FINAL Drainage Report.pdf Markup Summary

CDurham (51)		
PCD FILE # PPR2619	Author: CDurham Subject: Text Box Page Label: 1 Date: 7/24/2026 9:33:04 AM Status: Color:  Layer: Space:	PPR2619 DMC Response: PPR number added
Joushu Countv	Author: CDurham Subject: Line Page Label: 2 Date: 7/24/2026 12:20:34 PM Status: Color:  Layer: Space:	DMC Response: Name corrected
Joushu Countv	Author: CDurham Subject: Line Page Label: 2 Date: 7/24/2026 12:20:39 PM Status: Color:  Layer: Space:	DMC Response: Name corrected
ign Properties ings Move drawings to end of report	Author: CDurham Subject: Text Box Page Label: 3 Date: 7/24/2026 9:33:34 AM Status: Color:  Layer: Space:	Move drawings to end of report DMC Response: Drawings moved to end of report
are present on the site FIRM Map Number 00 Include a copy of the floodplain map in the appendix.	Author: CDurham Subject: Text Box Page Label: 4 Date: 7/24/2026 12:27:45 PM Status: Color:  Layer: Space:	Include a copy of the floodplain map in the appendix. DMC Response: Floodplain map included

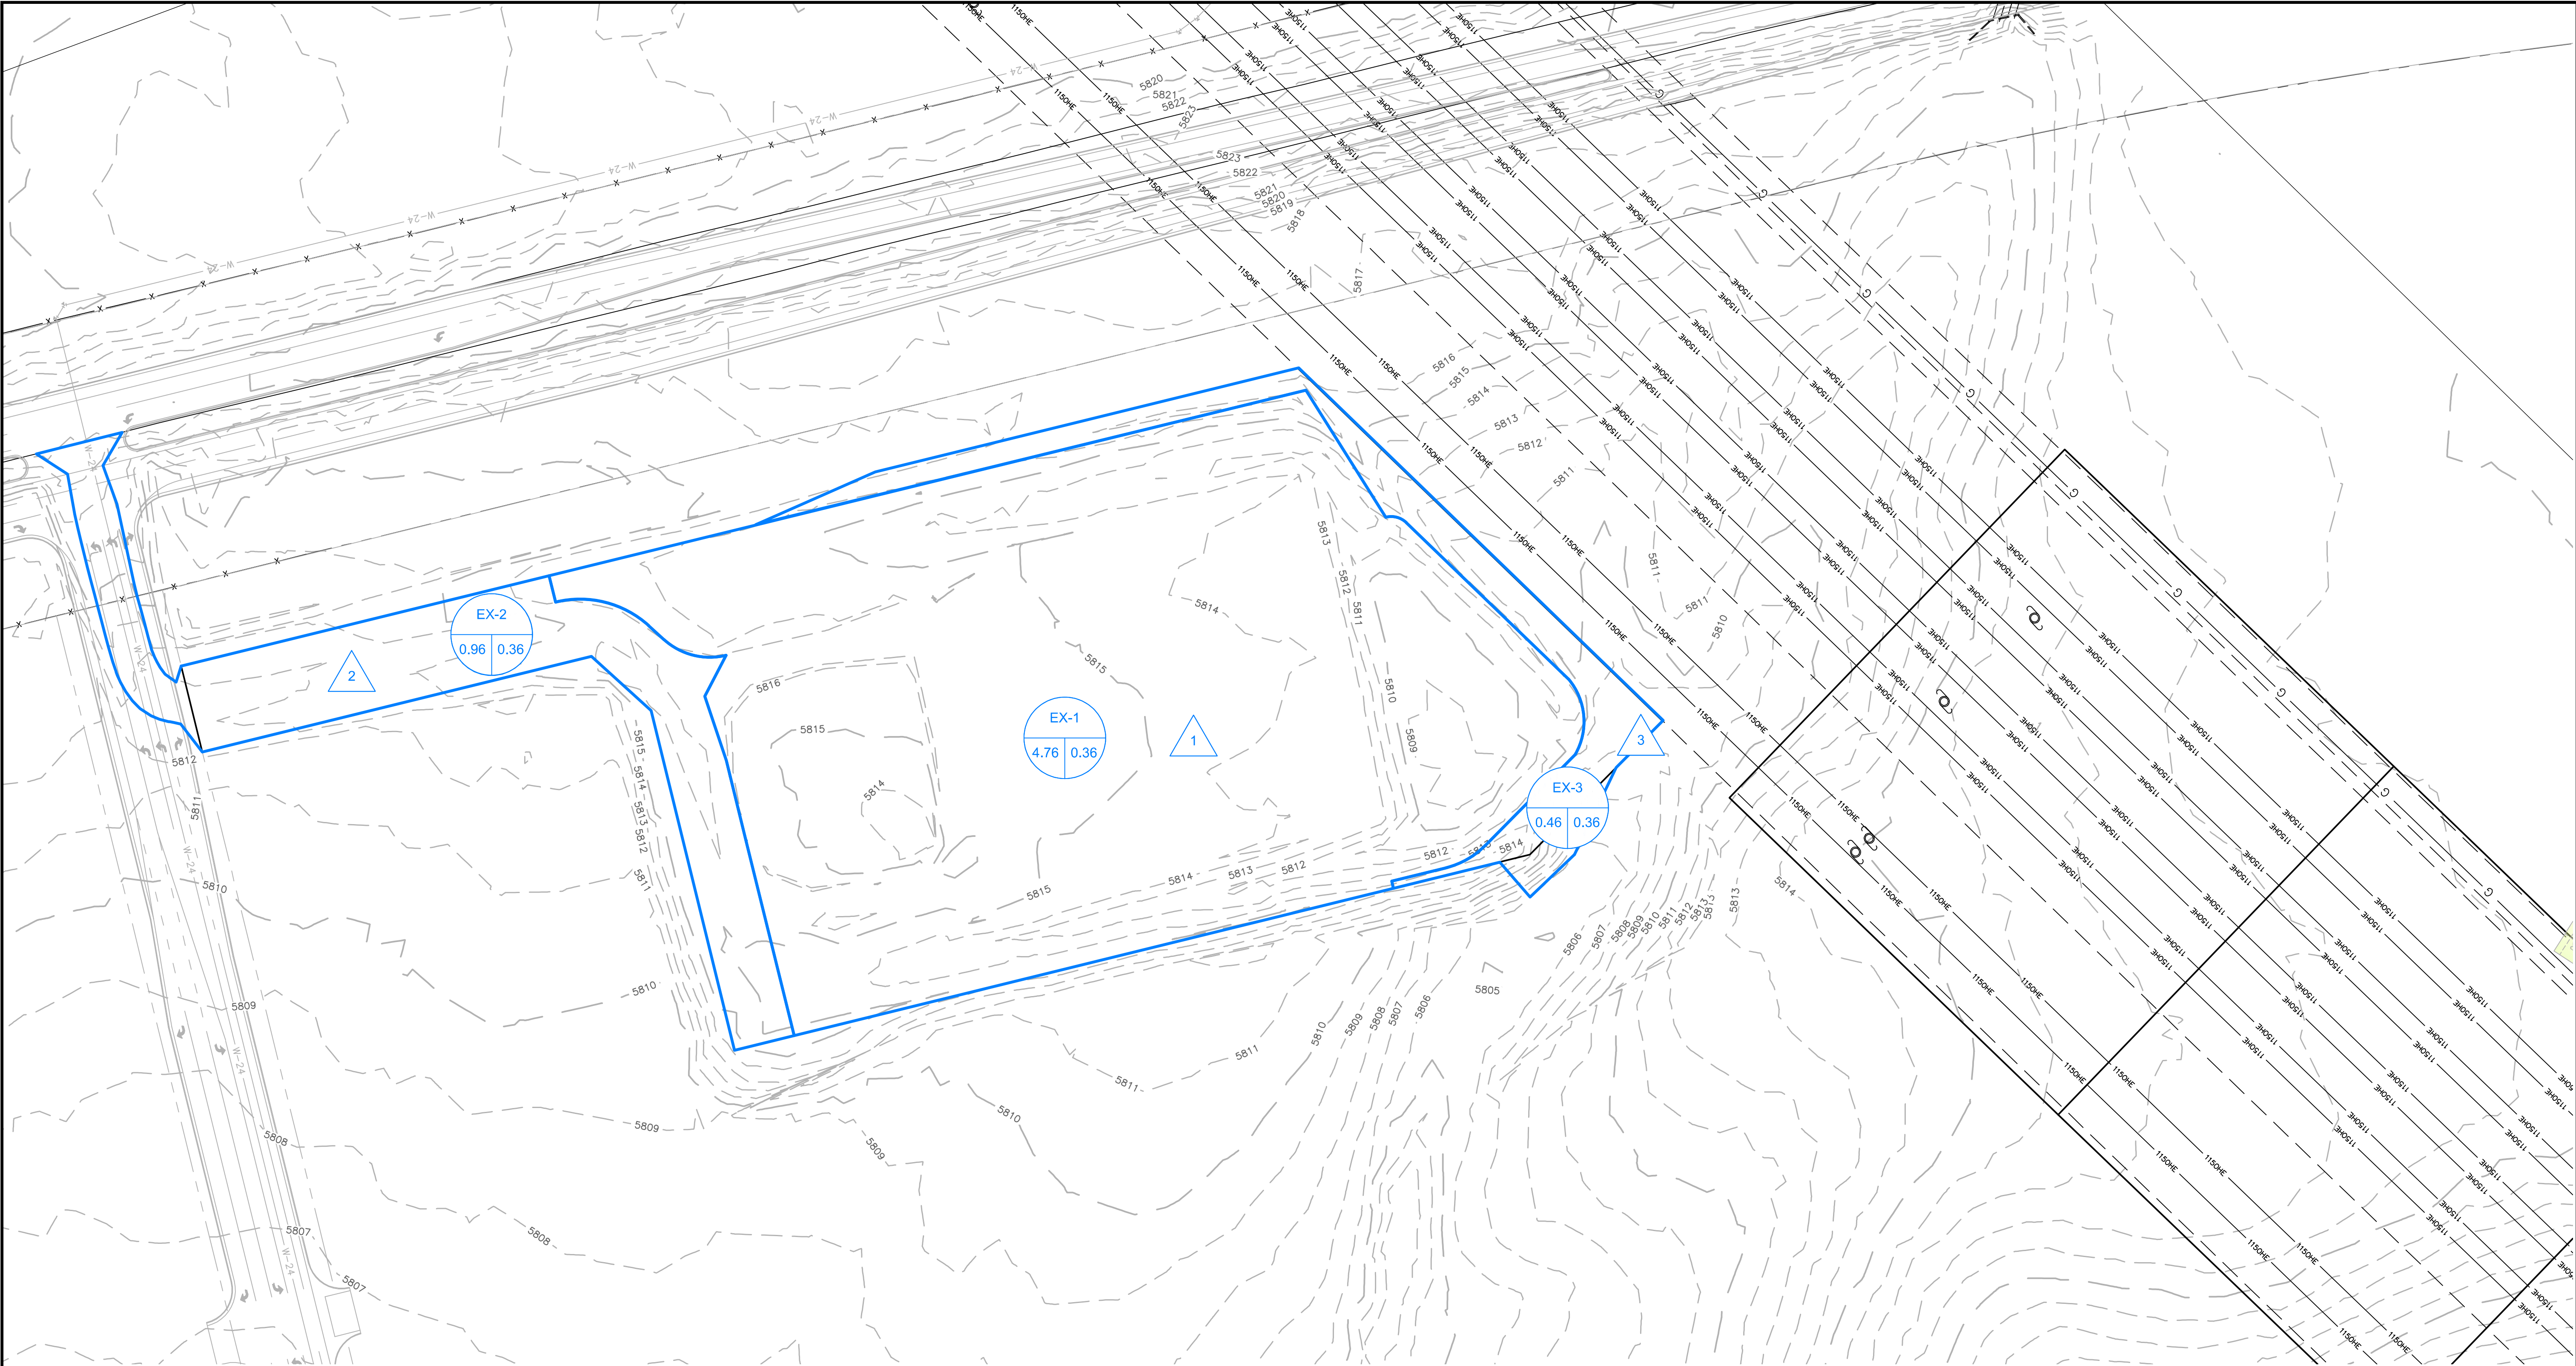
Label contours in here

Provide flow arrows

Flows do not match with SWMM model

Why? Entire project site should be analyzed, even if it's not treated. Please provide additional basins for these areas and determine existing flows.

Provide basin summary table

DMC Response: Contours added.

DMC Response: Flow arrows added.

DMC Response: Flow corrected to match SWMM model flows.

DMC Response: Basins updated to include entire property

DMC Response: Basin Summary table added to plans

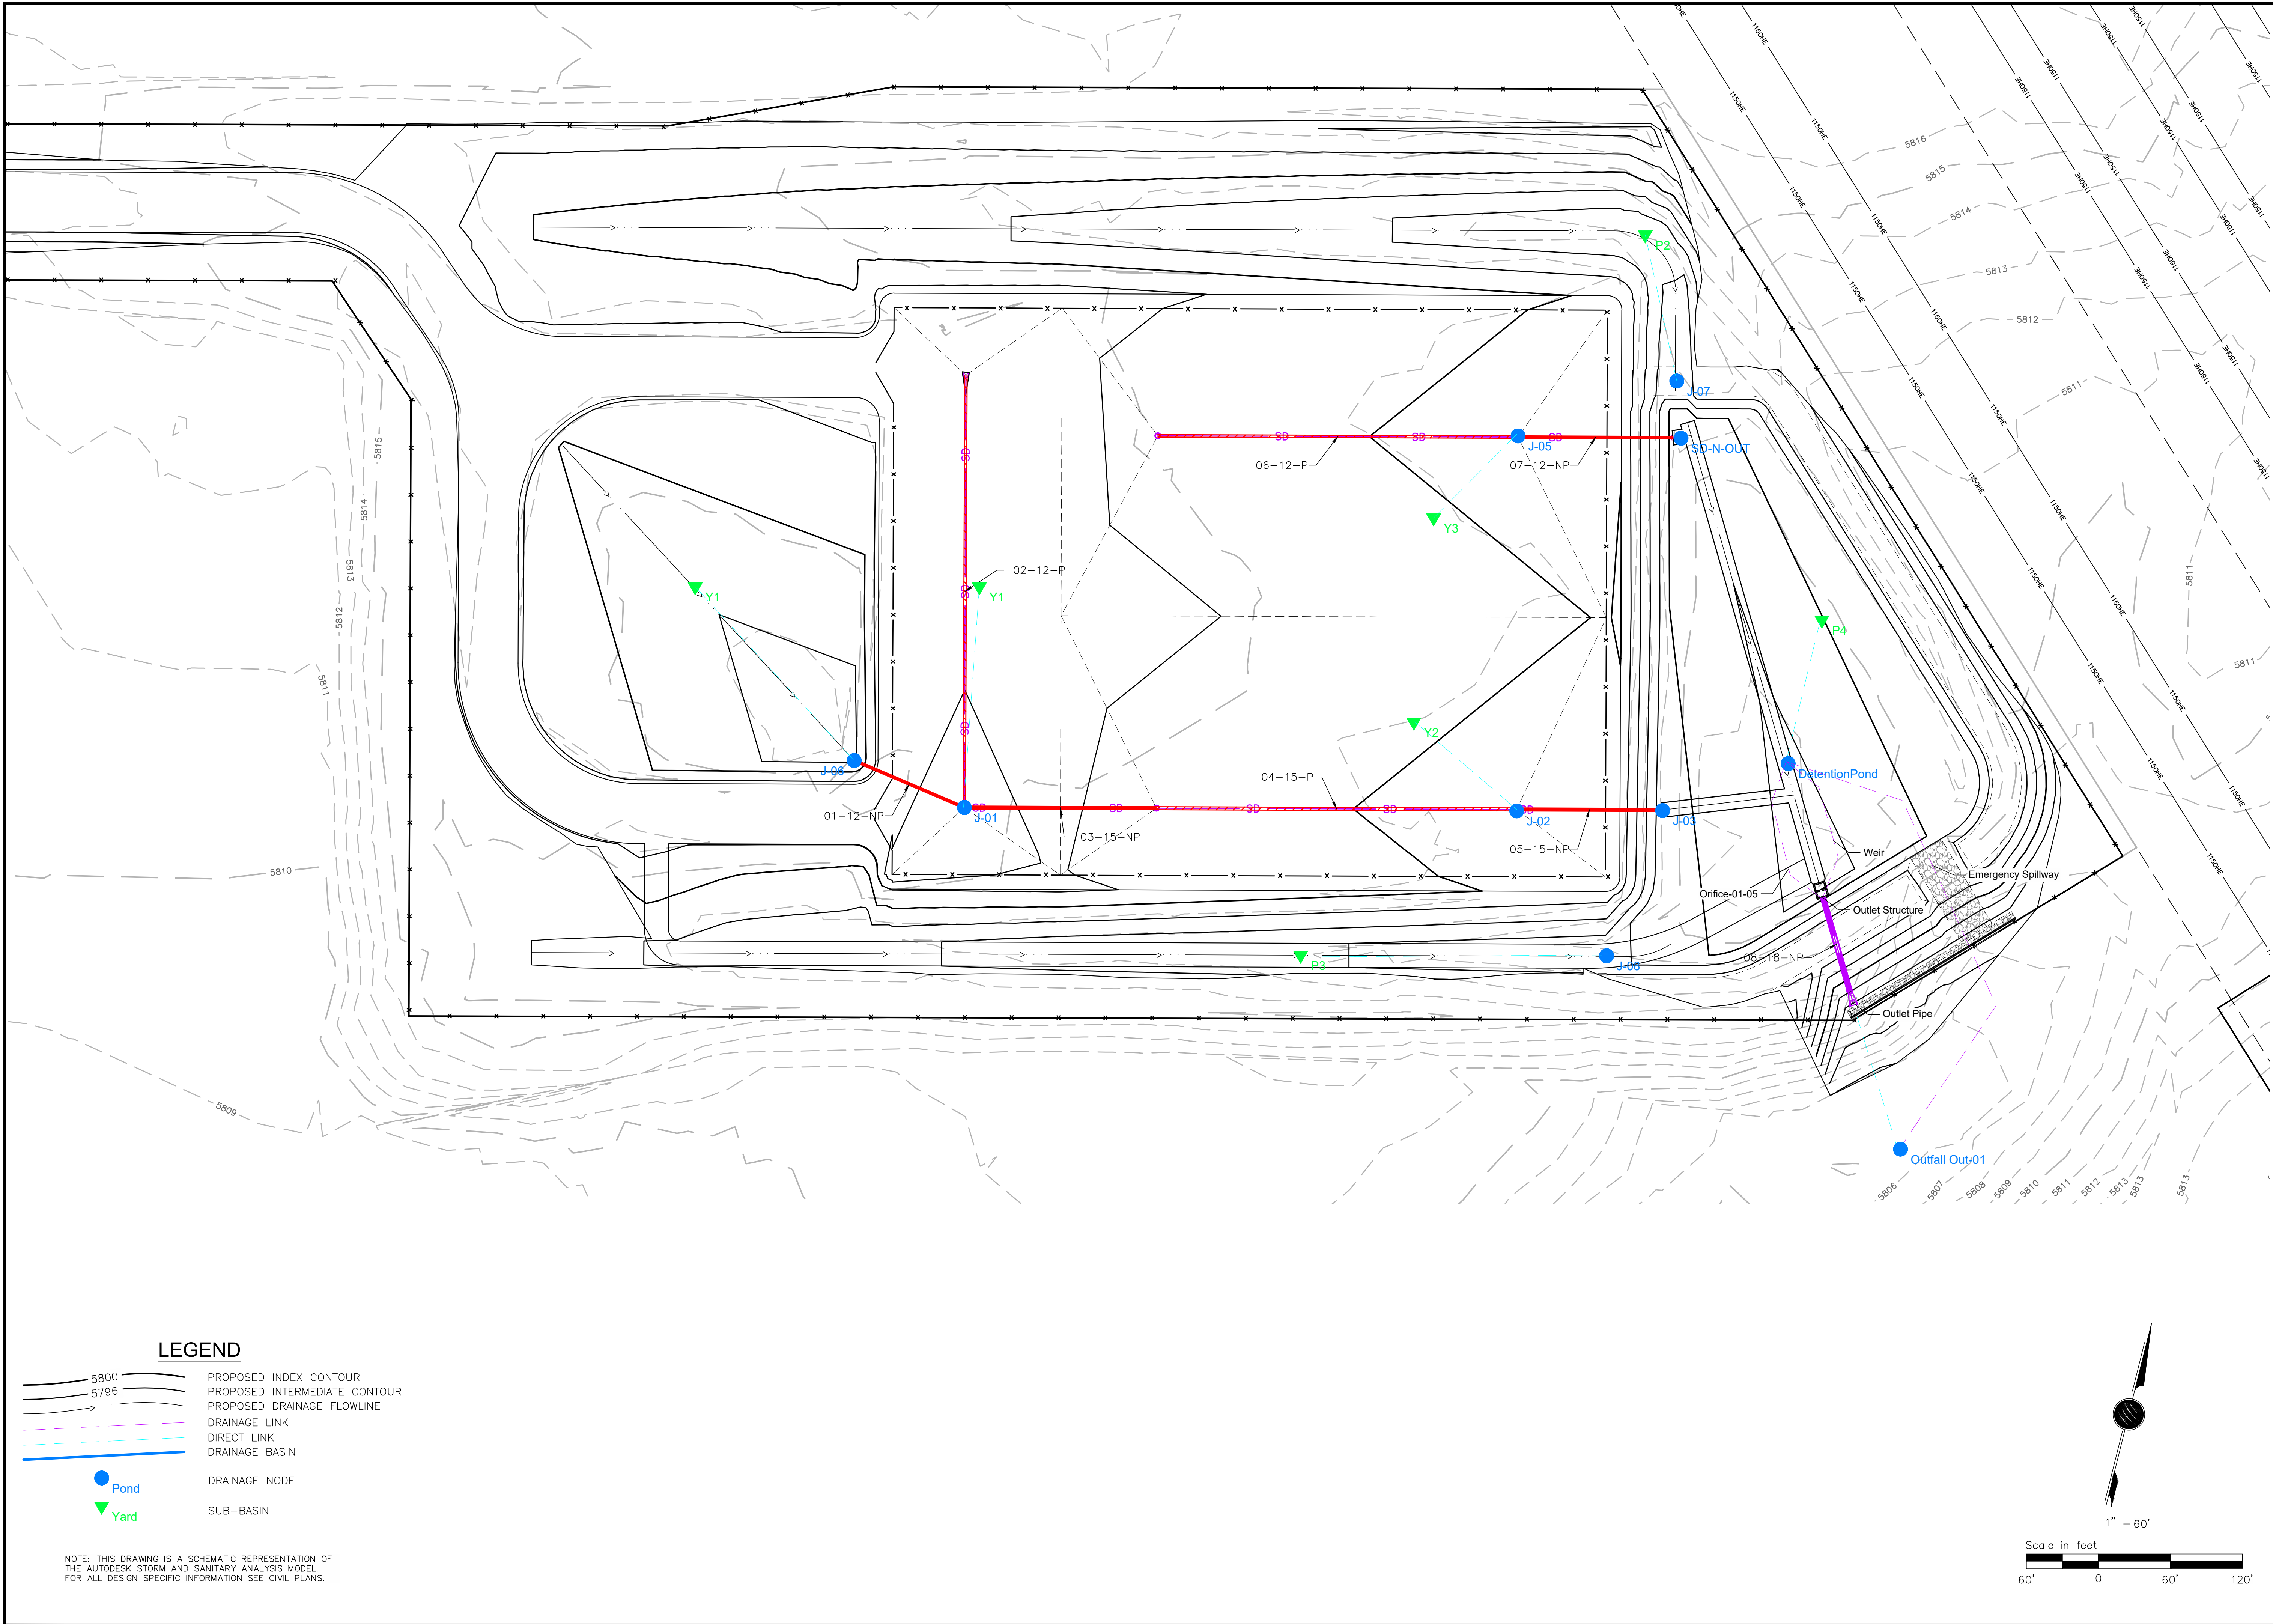
Why? Entire project site should be analyzed, even if it's not treated. Please provide additional basins for these areas and determine existing flows.

Delete table from this sheet

Add basin summary table

Include basin in hydrology calculations

Include basin in hydrology calculations

Label pond and all the parts of the pond

fix overlapping text

Label swale

Label swale

Provide riprap rundown from swale to pond bottom. Provide design calculations in appendix

Label high and low points

Label level spreader

DMC Response: Basin updated to include entire property

DMC Response: Table Deleted

DMC Response: Basin Summary table added to plans

DMC Response: Calcs revised to include basin

DMC Response: Calcs revised to include basin

DMC Response: Pond and all parts now labeled.

DMC Response: Label postilion adjusted

DMC Response: Swale labeled

DMC Response: Swale labeled

DMC Response: Riprap rundown hatching now included

DMC Response: High and low point labels added

DMC Response: Level spreader labeled

Basin ID: EDB-1

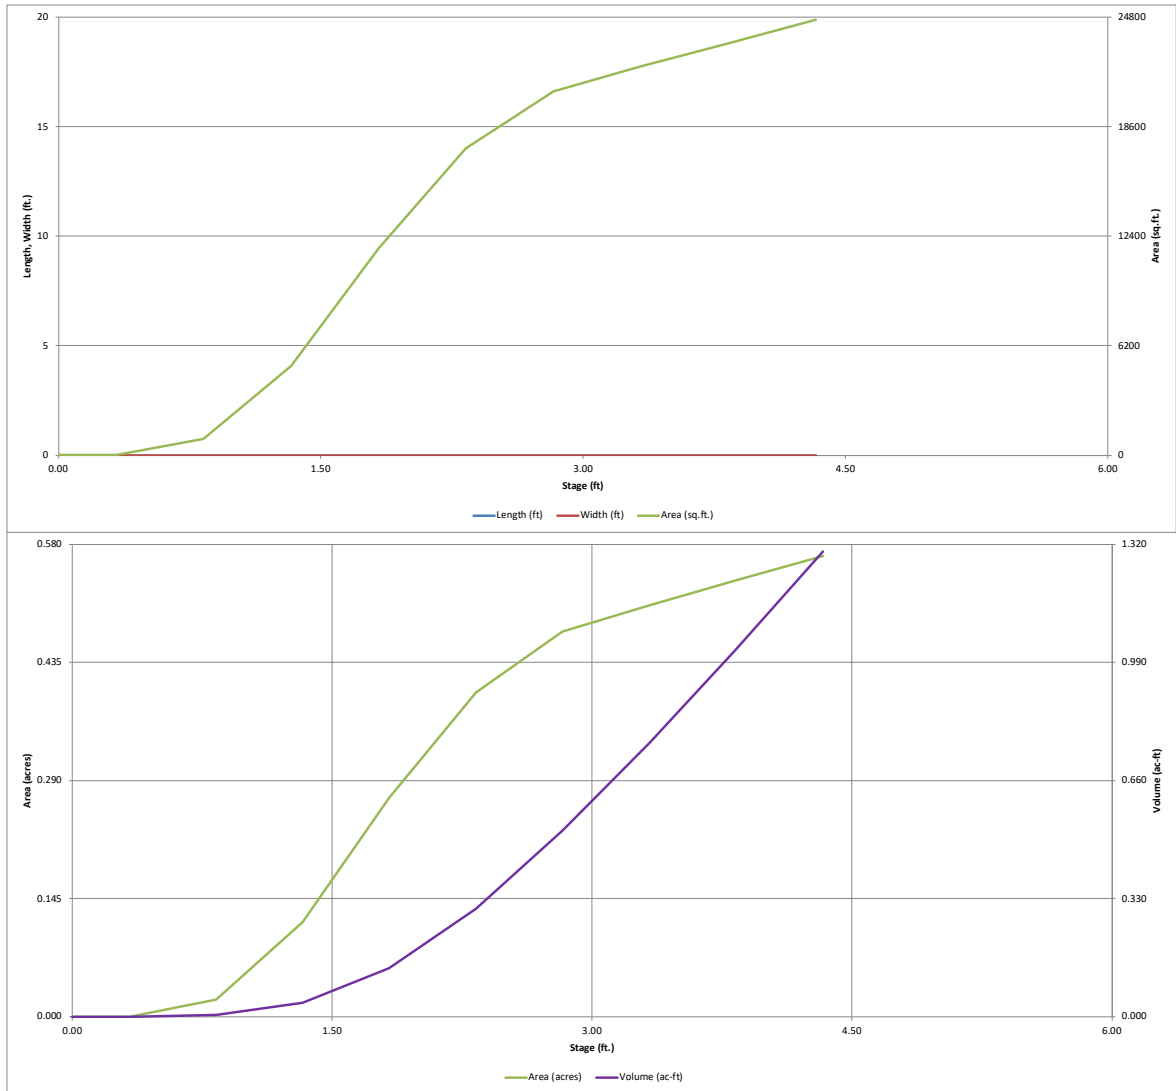
The emergency spillway shouldn't be activated in the 100-yr storm event, the pond outlet structure should be designed for the 100-yr.

DMC Response: Outlet structure overflow weir height reduced so the outlet plate is now the controlling structure, not the spillway.

DETENTION BASIN STAGE-STORAGE TABLE BUILDER

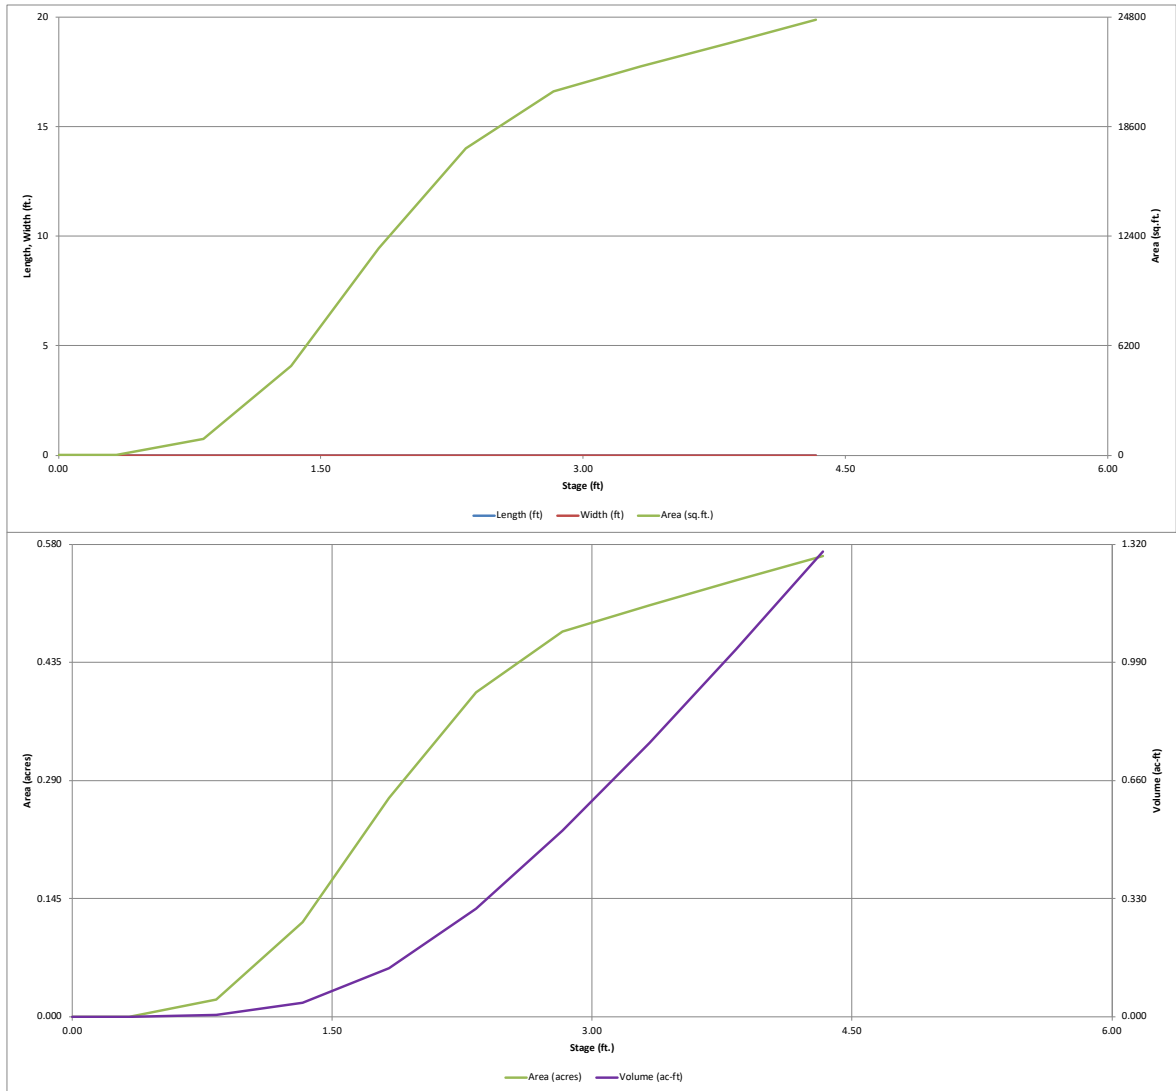
This is not the full disturbance area. The pond should treat the entire disturbed area or exclusions should be identified that apply to the untreated areas.

DMC Response: This value represents the area of water captured by EDB-1. As mentioned previously, the basins EXCL-1 and EXCL-2 are excluded, have respective exclusions applied.
